Our Ref: FE20/98#11

Your Ref: SSD-10448

**Consultation for comment on EIS – Aspect Industrial Estate – Mamre Road, Kemp's Creek  
(Lot 54-58 DP 259135) – SSD 10448**

Figure 8 – Plan of proposed stream realignment.

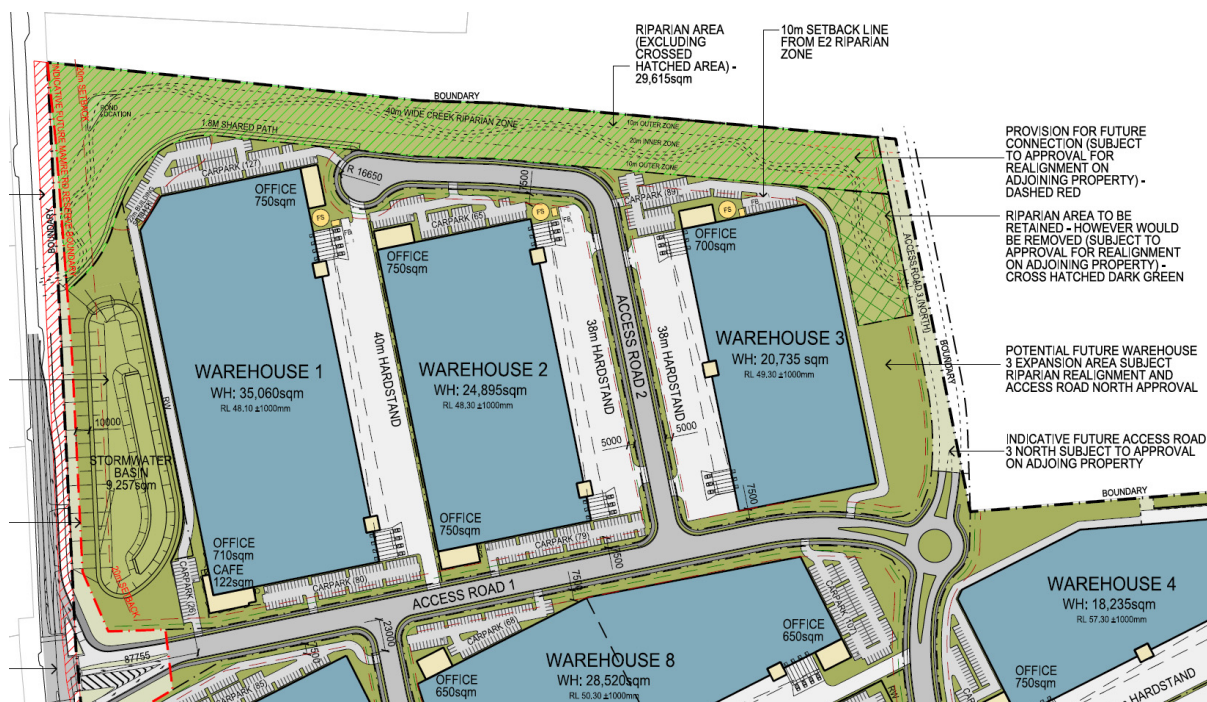
- Any water discharged from the development will flow into Ropes Creek (West) or Kemps Creek (East - which is identified as KFH) and must meet the relevant ANZECC guidelines for water quality.
- DPI Fisheries requires further clarification why the realigned creekline is required to be classified as an 'artificial' waterbody. This means future works may be exempt from FM Act and its important objectives.
